# Triton Knoll Offshore Wind Farm Limited Triton Knoll Electrical System

**Appendix 26: Development  
Consent Order Schedule of  
Amendments Explanatory  
Document**

**Date: 1<sup>st</sup> February 2016**

# Schedule of Amendments for Deadline 5

Figure 1. Diagram of a typical root system

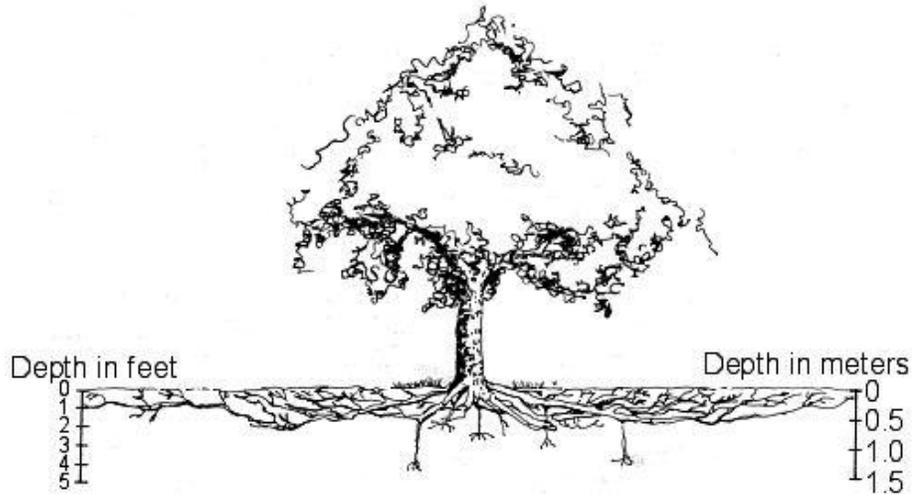
5.5	As above		“90. The suggestion that the restriction is required to guarantee against tree route damage is without foundation.”		The Applicant’s view is that the protection of the cables, both for system integrity and for the safety of the public, is paramount in determining what restrictions are required in proximity to the cables. Deep rooted species have the potential to affect the integrity of the cable ducts and ultimately the cables themselves,

<p>should roots grown between or under ducts. Over time, strong root systems in deep rooted species can heave cable ducts and disrupt cable joints and can crush cable ducts and affect the integrity of the cable sheath and ultimately the cable core. Should this occur the presence of deep root systems is likely to increase the complexity of the remedial action required. In addition larger trees, if felled by wind throw, provide the potential to expose the cable ducts should the root plate topple and bring large amounts of soil with it.</p> <p>The Applicant's view is that the approach where restrictions would have to be placed on the size of above ground growth, and management of all planting across the cable route would have to be undertaken by landowners to ensure compliance, still creates too great a risk to the integrity of the cables.</p>
--	--	--	--	--	--
